From: Martyn White
Sent: 04 September 2014 14:23
To: James Smith
Subject: EG/55/14/PL, EG/56/14/PL, EG/57/14/A, EG/59/14/PL Comments on revised Plans

Application Number	EG/55/14/PL, EF/56/14/PL, EG/57/14/A, EG/59/14/PL REVISION
Address	The Barnham Hotel 28 Barnham Road Barnham PO22 0ES
Description	Various – See below
Case Officer	Mr. S. Davis

PROJECT PROPOSED TESCO EXPRESS BARNHAM BRIDGE INN 28 BARNHAM ROAD, BARNHAM WEST SUSSEX, PO22 0ES			
DRAWING TITLE ELEVATIONS AS PROPOSED			
DRAWN BY MMK	CHECKED BY MBH	DRAWING No. 9782-815	REV
SCALE 1:100@A1	DATE AUG 2014

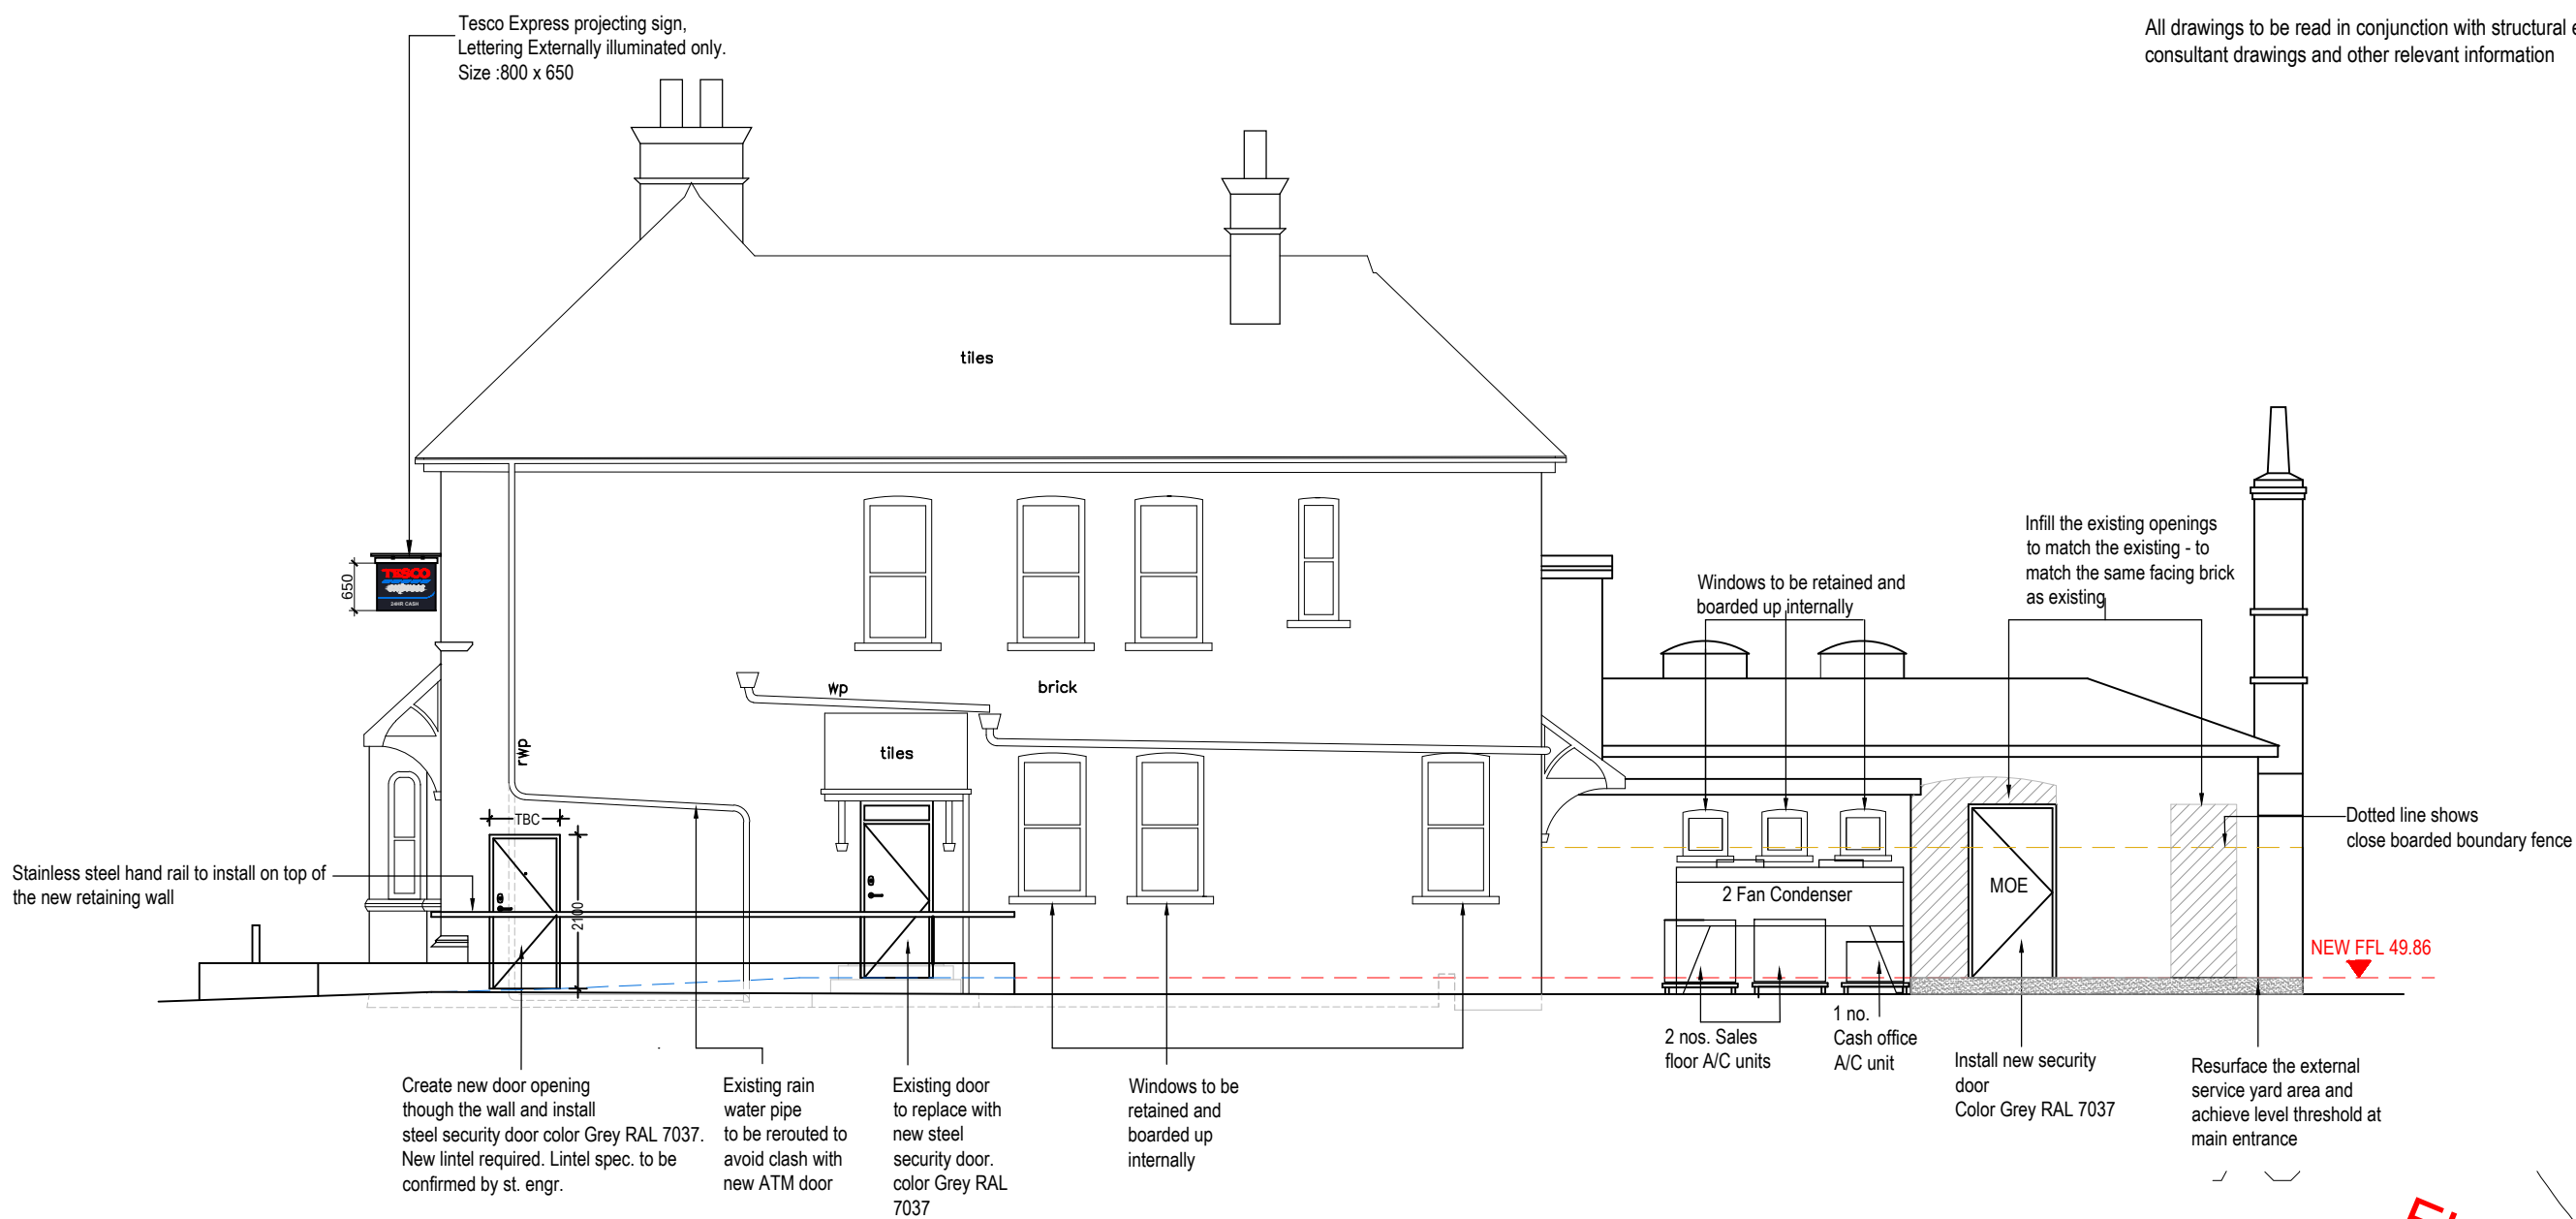
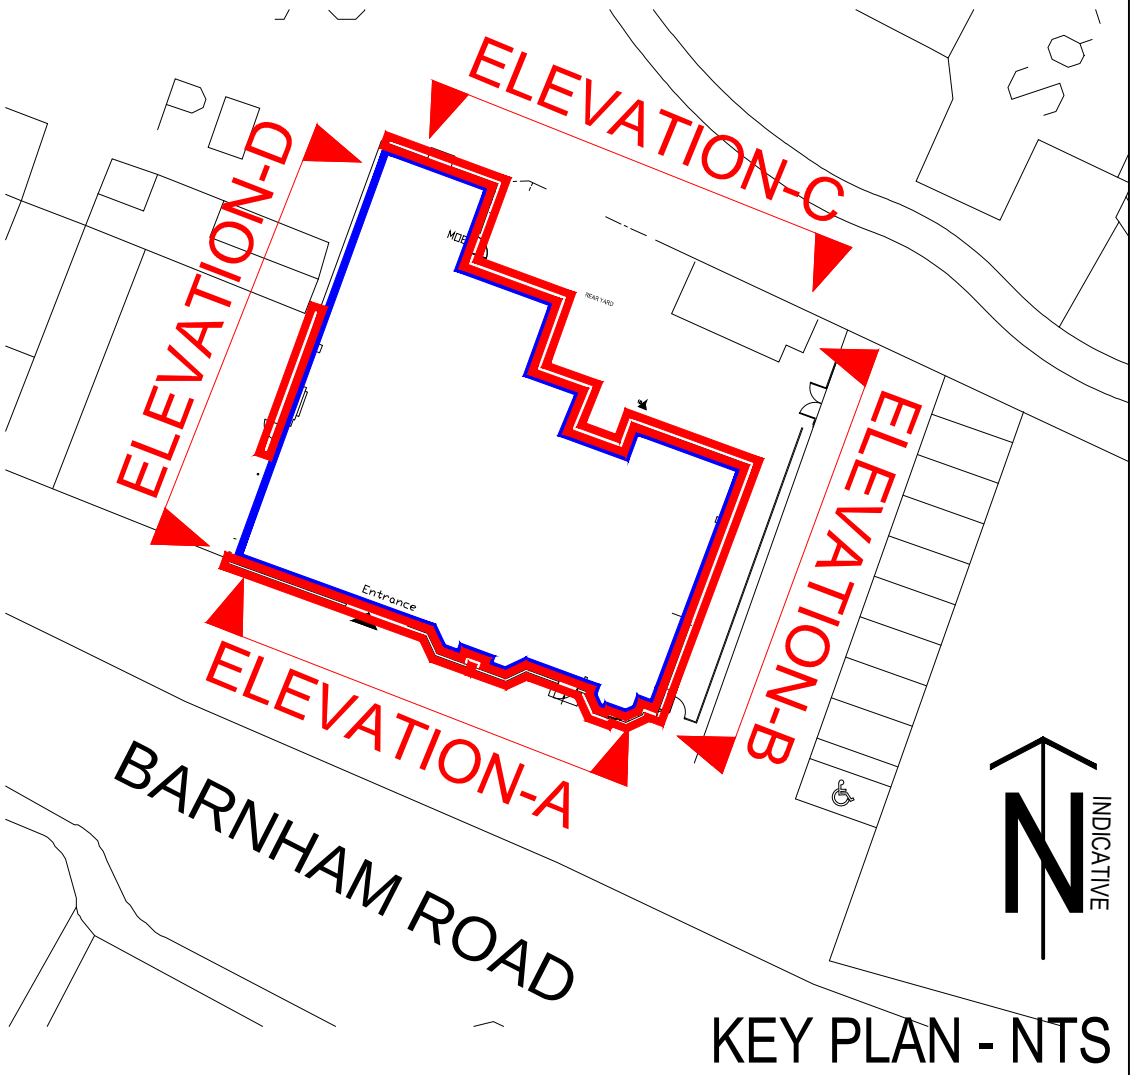
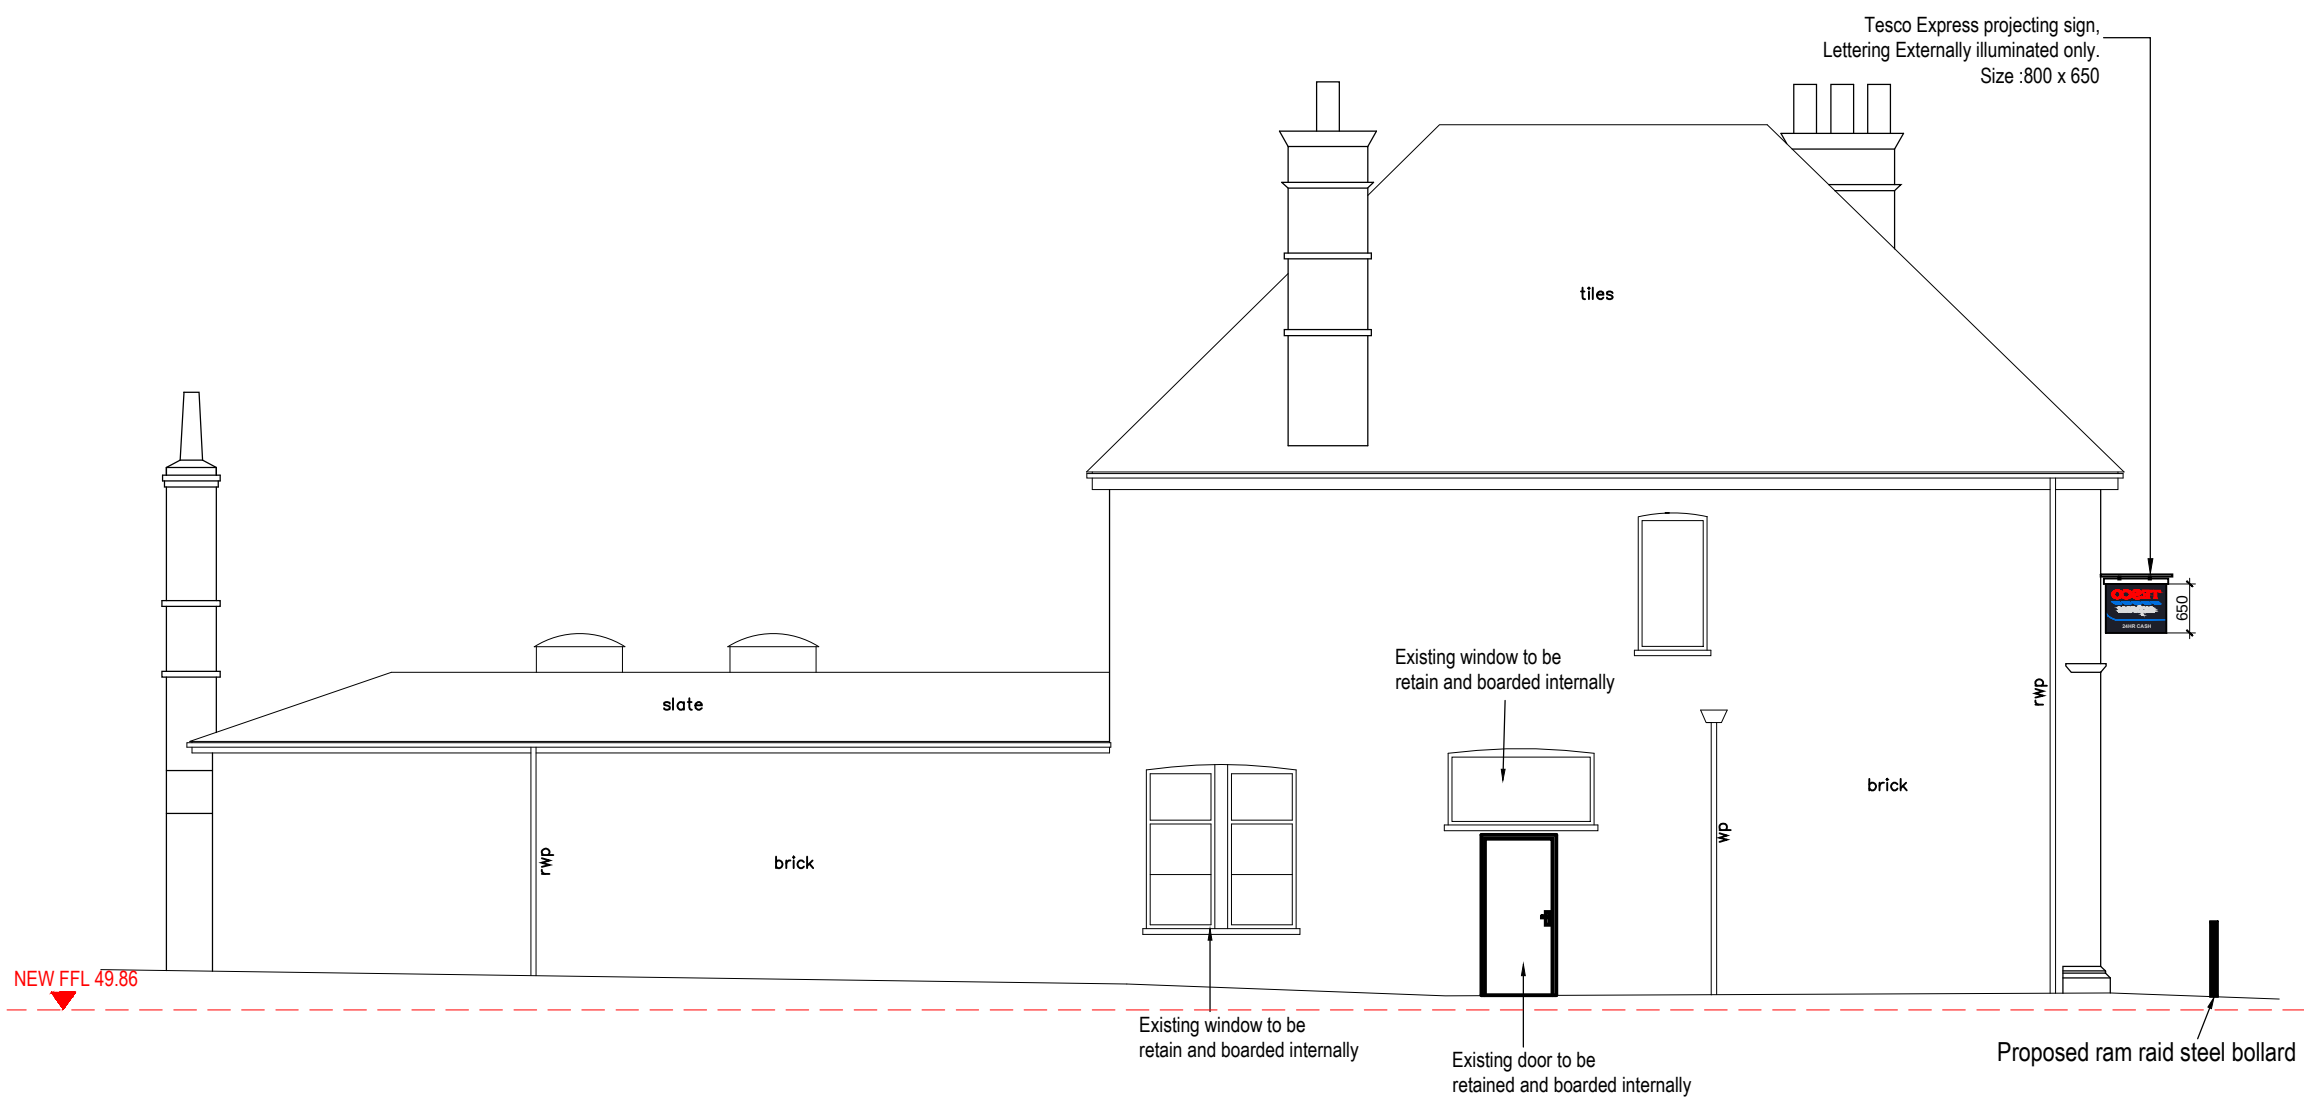
EG/55/14/PL: Details of how the cast machine steel security panel will be treated have been supplied, and they appear to be acceptable

EG/56/14/PL: the use of frosting and the retention of the decorative glass panels is supported
